Item No. **Report of the Head of Development Management and Building Control**

Address: 1 SEDGWICK AVENUE HILLINGDON

Development: Erection of an attached 2-bedroom dwelling

LBH Ref Nos: 18794/APP/2023/1934

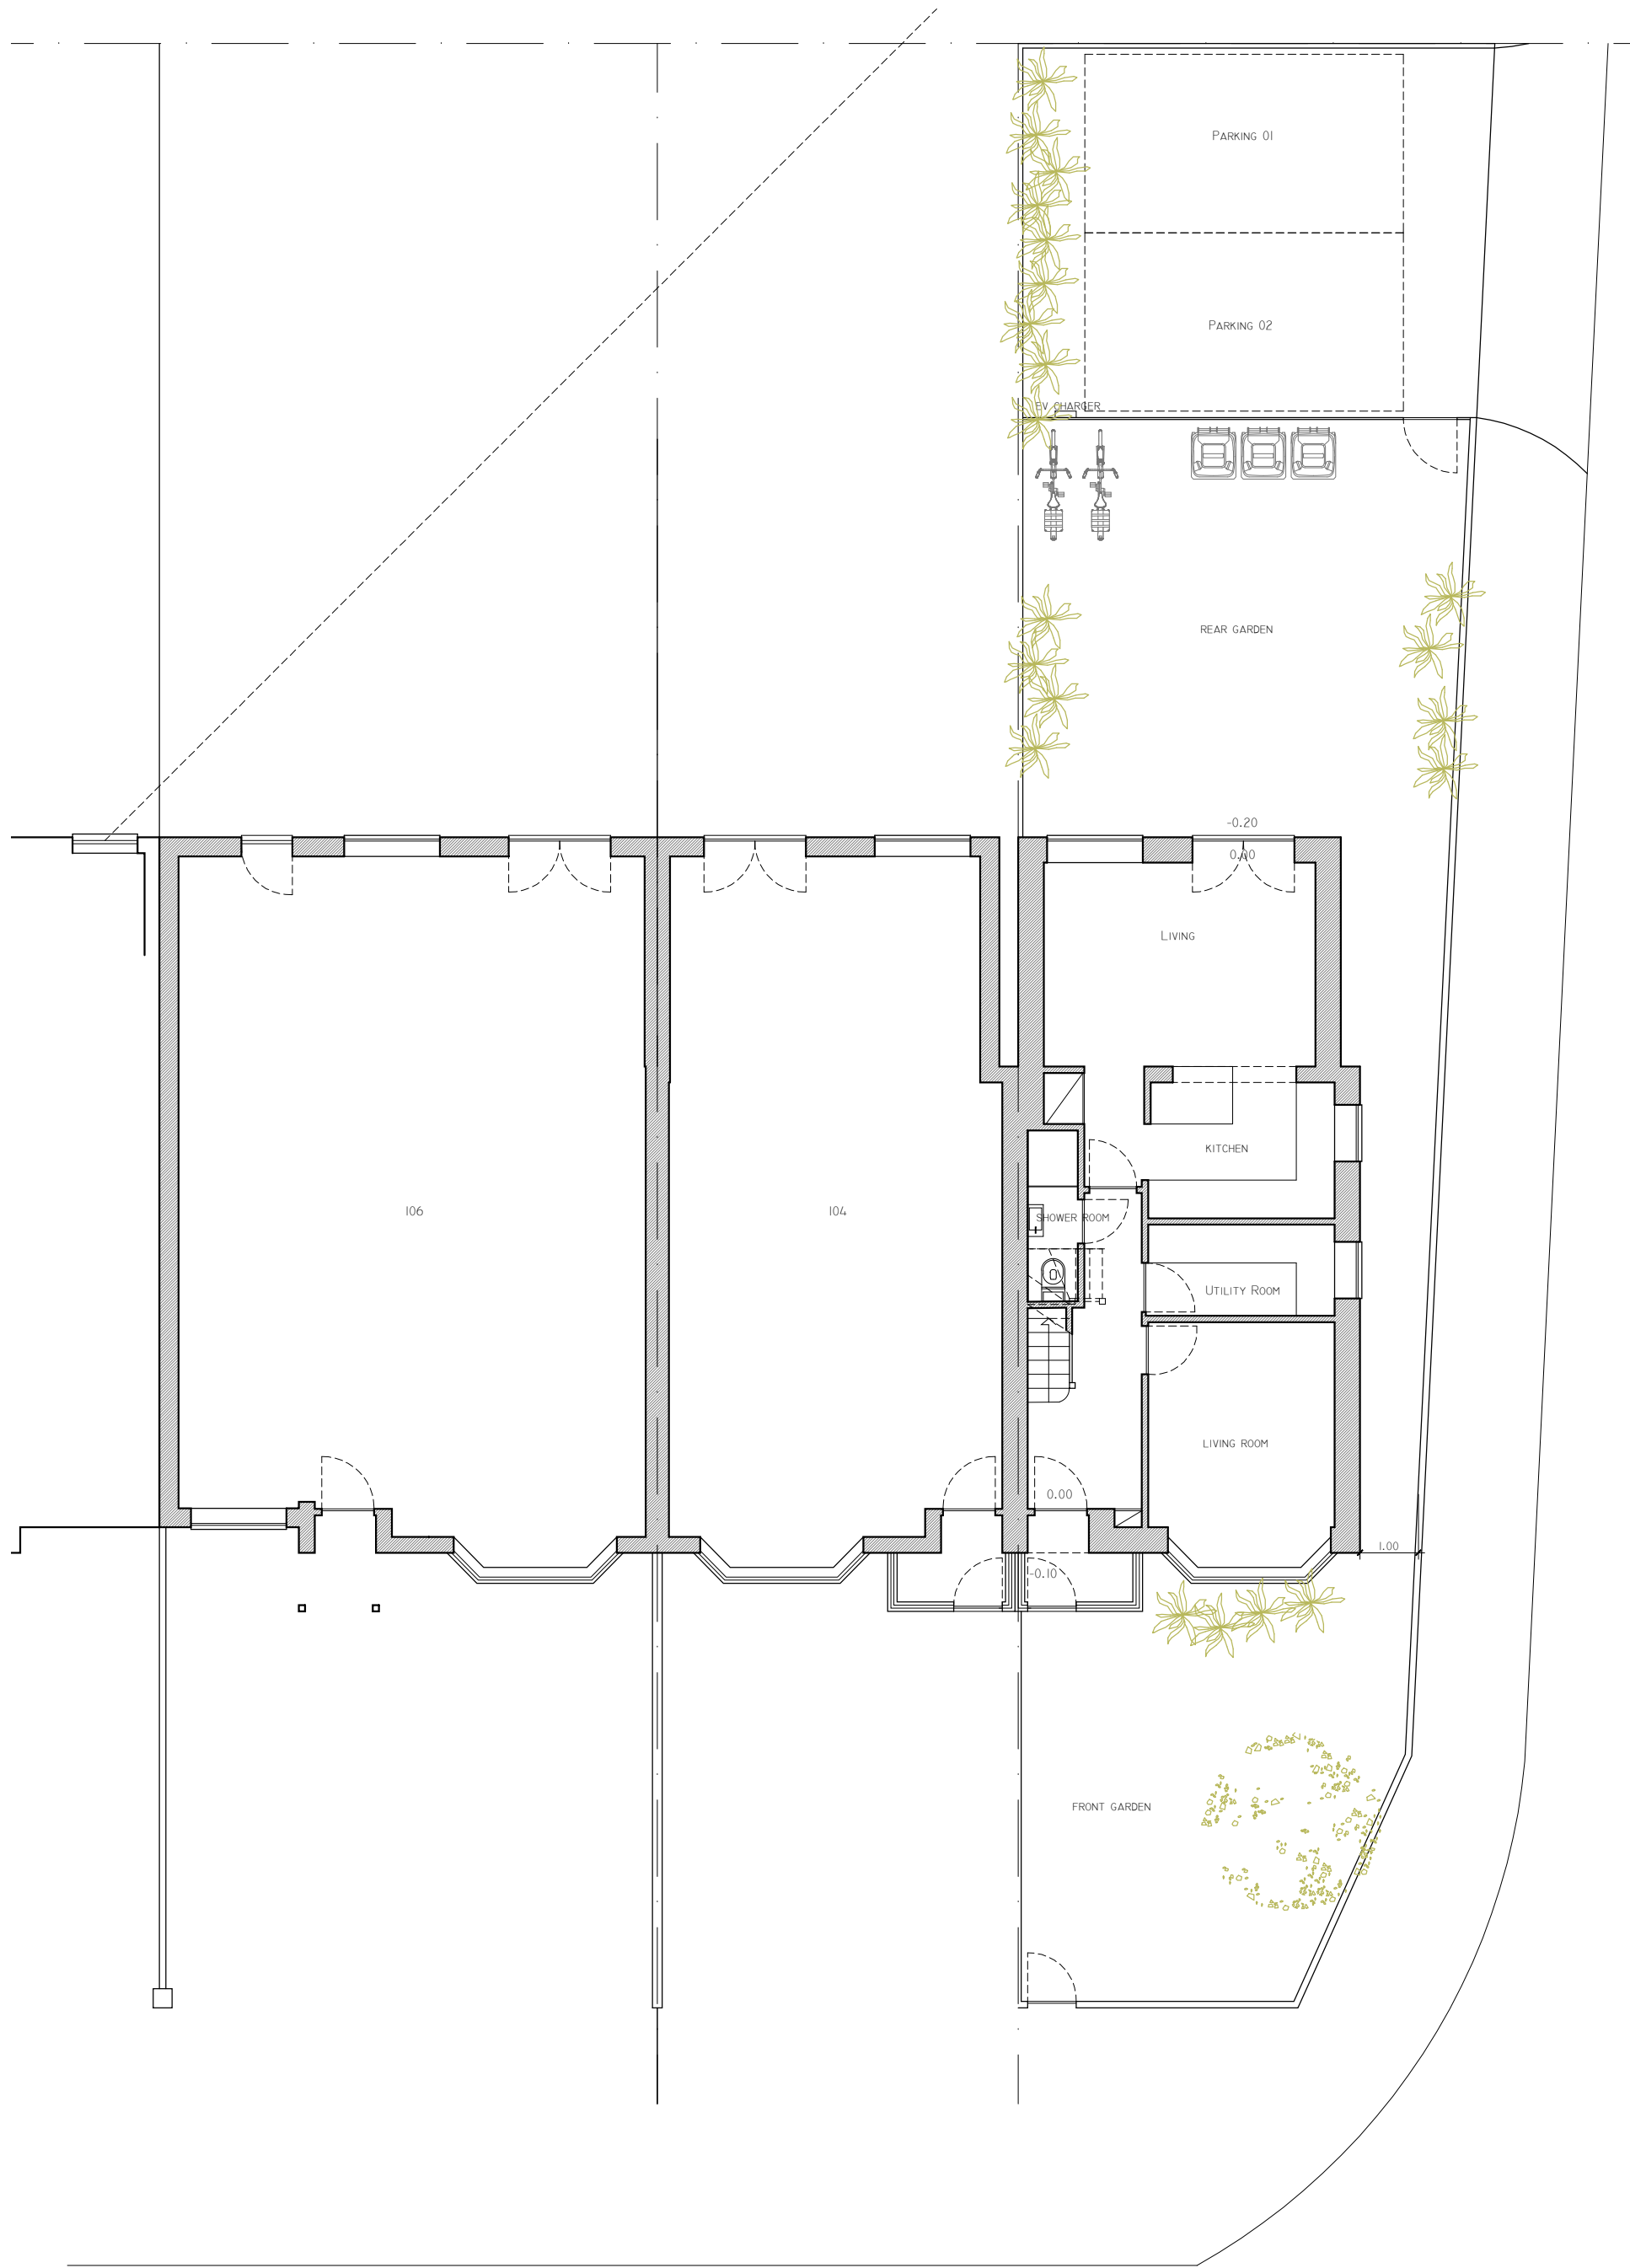
Having reviewed the proposed site plan concerns are raised within regards to the lack of detail to demonstrate adequate and safe access to the parking space which will serve the existing dwelling. As such the proposal could result in the displacement of parking on street which could be detrimental to the local highway network. No evidence has been submitted to demonstrate that there is sufficient capacity on street to absorb any potential displacement.

The proposed site plan indicates that the new dwelling will use the existing crossover to access the parking area at the front of the site. The Highway Officer has reviewed this considers the arrangement to be broadly acceptable. However no details have been provided to demonstrate how the illustrated to serve the existing dwelling will be accessed as the design of the existing vehicle crossing and the segregation of the frontage to form two segregated properties do not permit access into the parking area to be constructed to the front. Without these details and in the absence of a parking stress survey it cannot be confirmed whether the proposal would result in parking displacement on street where they may not be sufficient capacity.

In summary whilst the proposal indicates adequate levels of parking on plan, the proposed drawings do not provide the detail to demonstrate that access could and will be provided across the pavement to the space at the front of the existing dwelling which could result in the displacement of parking on street where there may not be sufficient capacity. As such an objection is raised on highway grounds and this forms a reason for refusal.

GROUND FLOOR

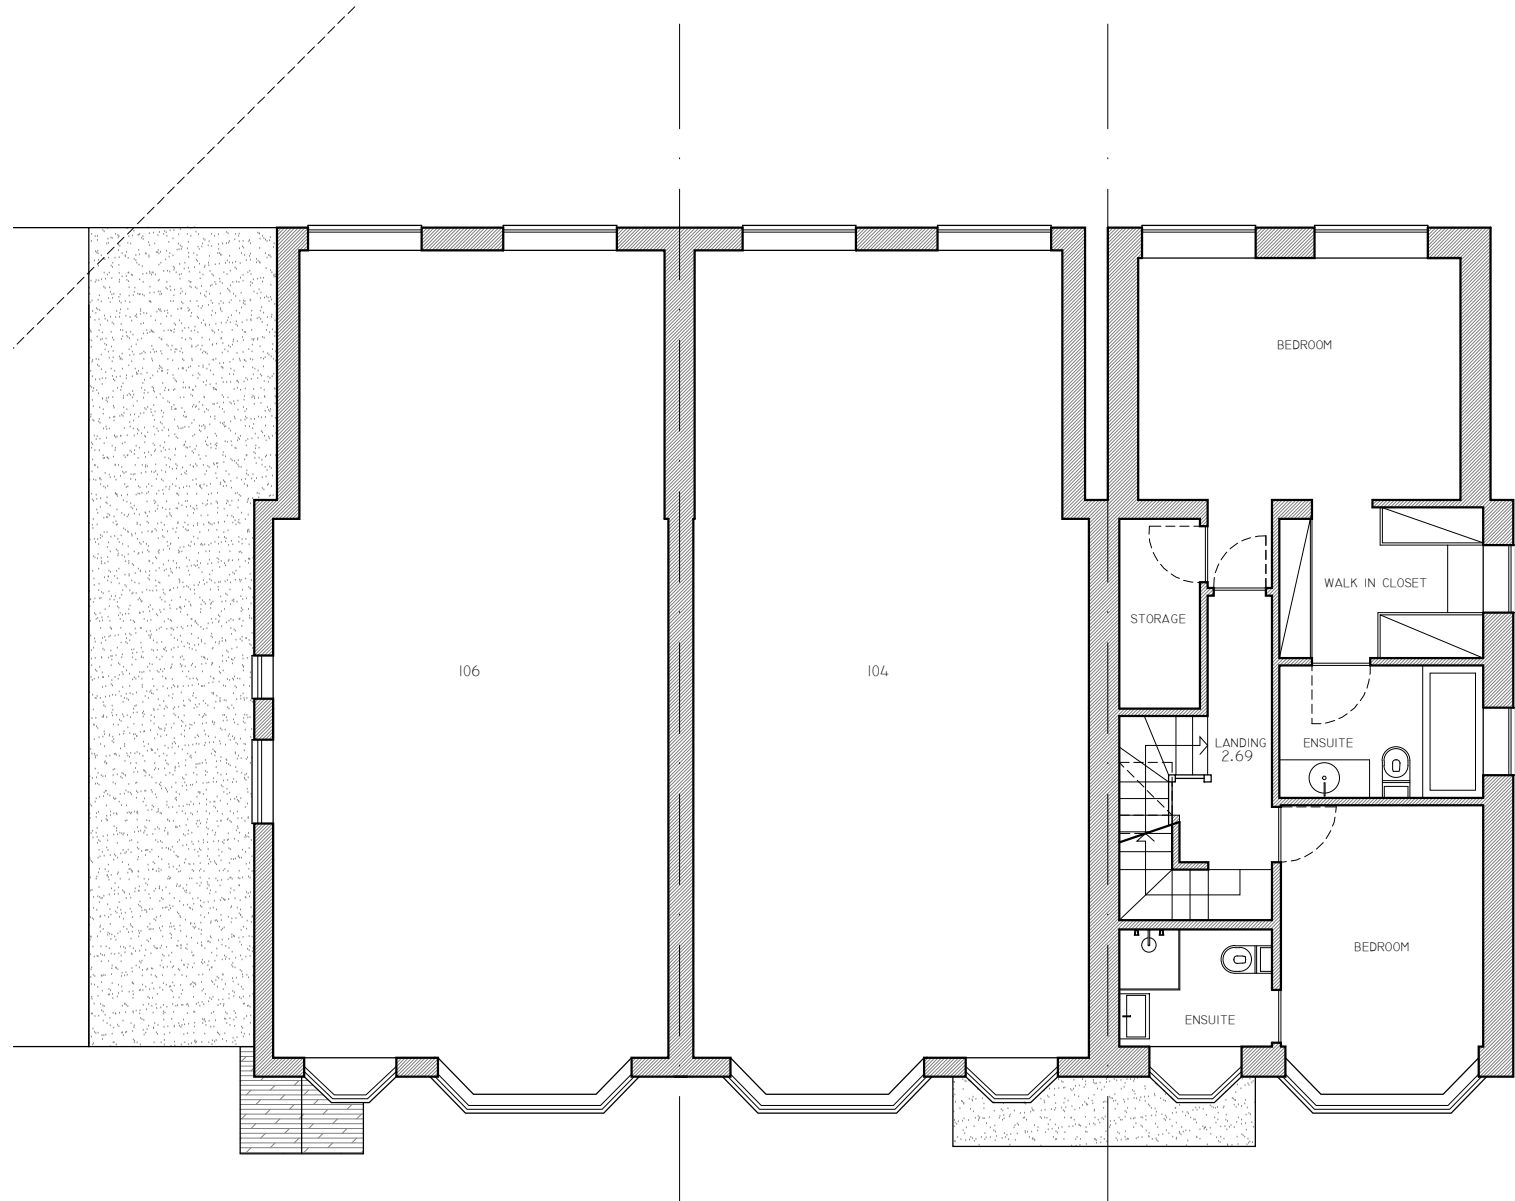
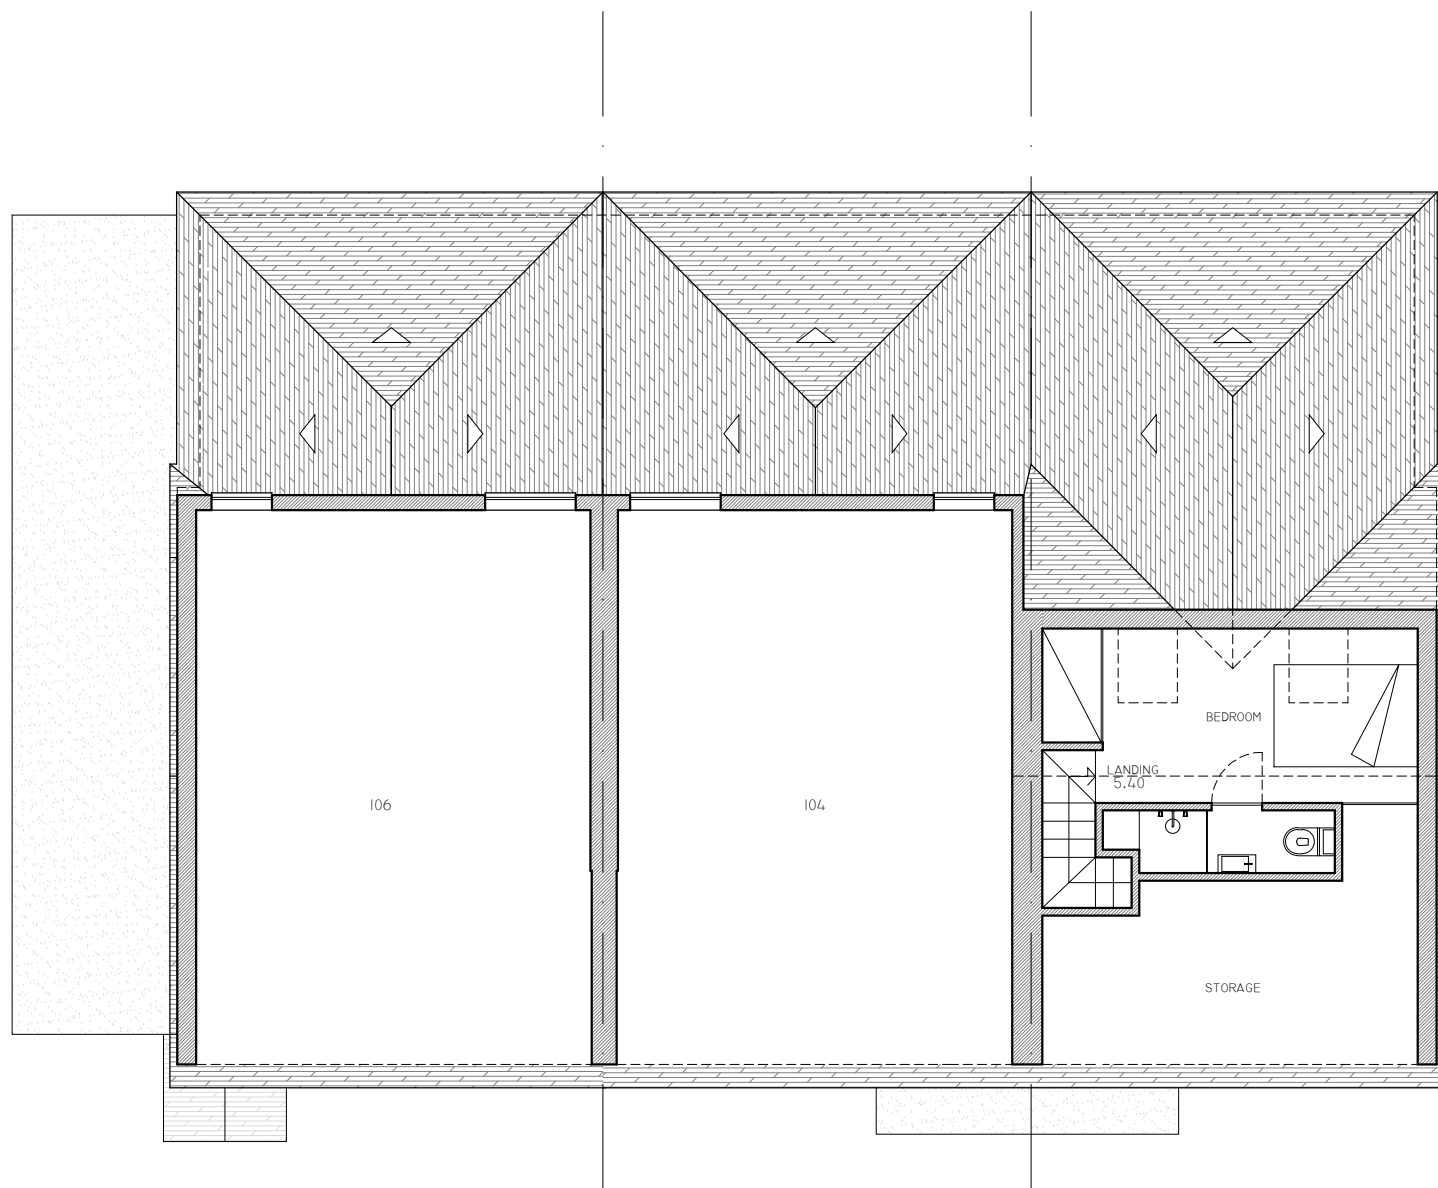
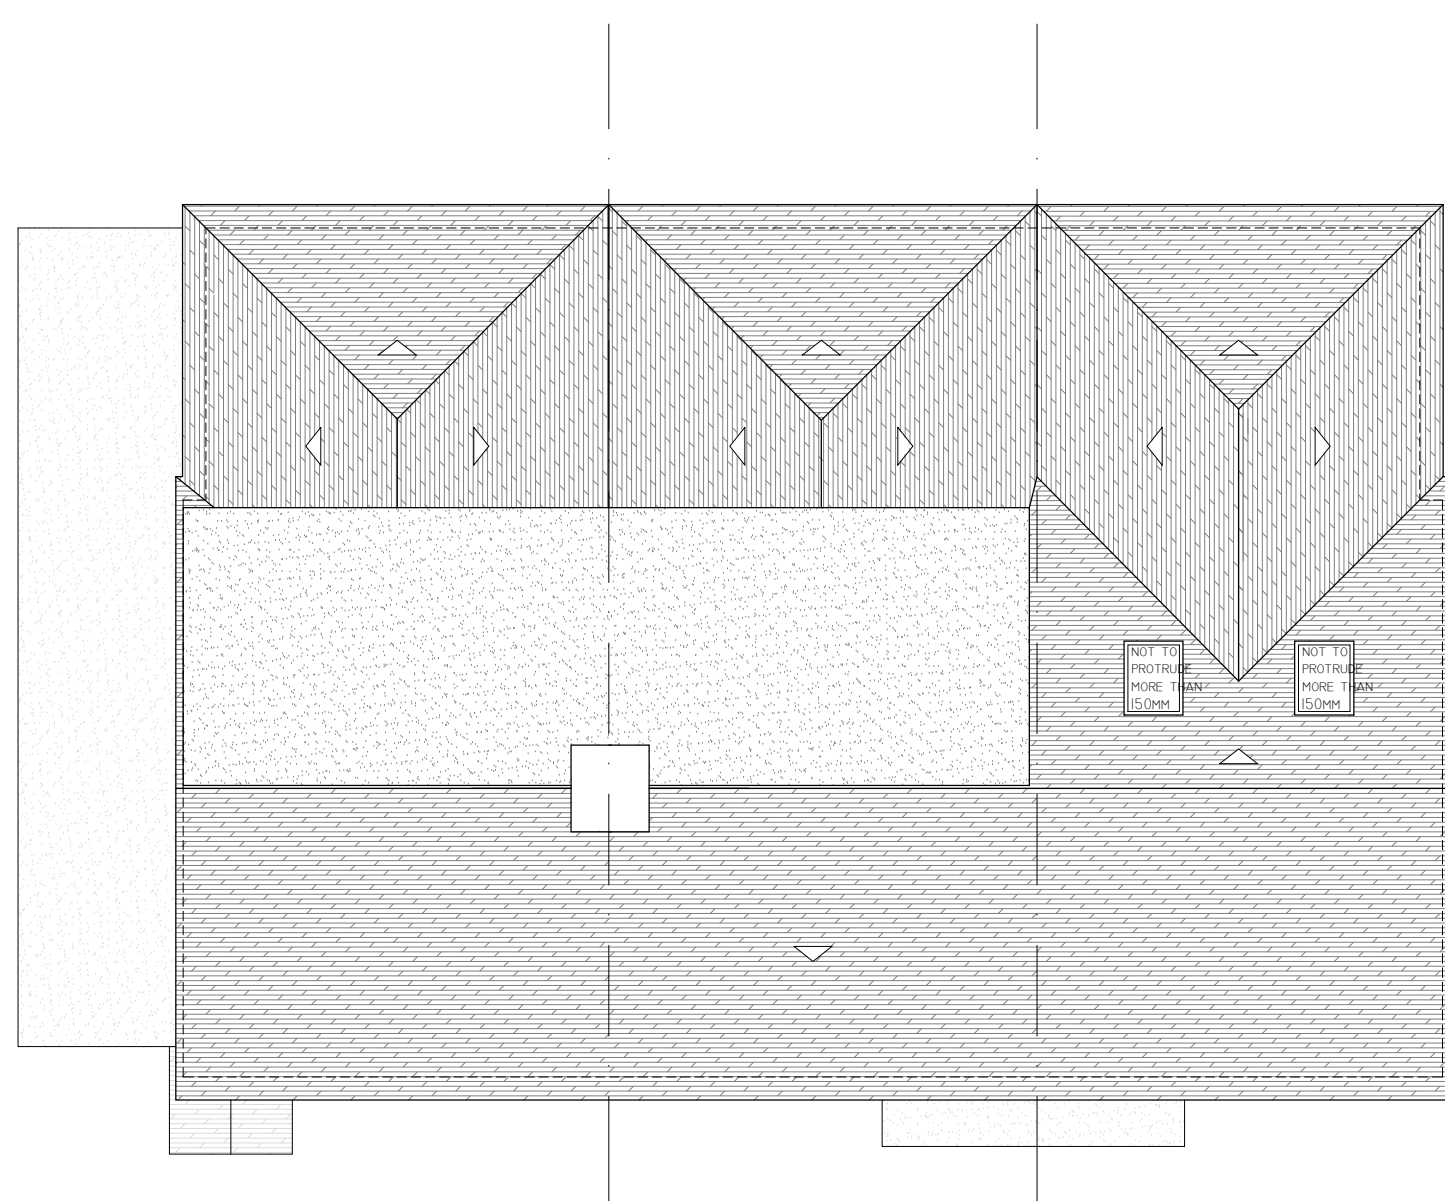
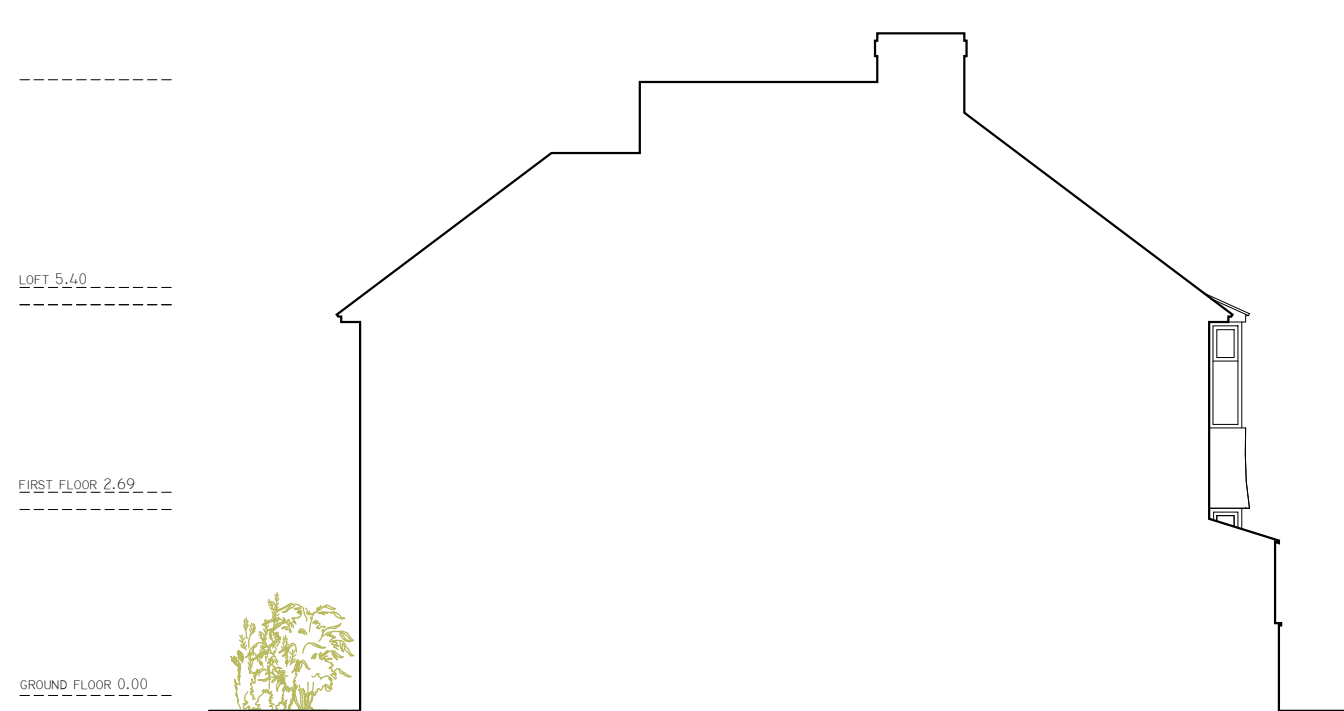
of 4 terraced properties with No.1 and No.7 forming the two end of terraces. Both properties benefit from the same design features which include the large projecting front gables that remain unaltered. As such the symmetry within this terrace remains in tact. The proposal would involve the construction of a building directly onto the side of No.1 with a front elevation measuring 5.3 metres in width, which is approximately the same width as the existing front elevation. DMH6 states that garden land development should appear smaller and more intimate in scale, it is clear that doubling the scale of the front elevation would not appear to be more intimate in scale and would not appear subordinate. Furthermore the front elevation would feature a hipped roof which would extend across the building line of No.1 to join the ridge of the existing gable. This creates an excessive and over dominant roof form. Moreover the proposal features a front and rear building line which would sit further forward and behind respectively which would detract from the uniformed building line of the terraced dwellings and in particular the two end of terraced properties.

Whilst the application property does benefit from an existing garage to the side which would be demolished to make way for the construction of the new dwelling, this is single storey therefore does not add additional and more dominant bulk and mass to the upper floor level and the roof therefore is distinctly less prominent. This point is compounded by the ground floor left front element which extends excessively beyond the front elevation of the existing property which makes for an uncomfortable front building line and distorts the general uniformity of the existing pattern of development. The existing garage protrudes marginally beyond the existing front elevation of the main dwelling but the proposed new dwelling would be much more prominent in appearance given its scale.

In summary, the scale bulk and massing of the development fails to appear a subordinate addition to the street scene and the example of similar development provided is not considered justification in a favour of this application. The design would result in an imbalance of symmetry between the terraced dwellings and would result in an incongruous and cramped form of development and an overdevelopment of the site. As such the proposed development fails to comply with DMHB 11 and DMHB 12 of the Hillingdon Local Plan: Part Two - Development Management Policies (2020) .
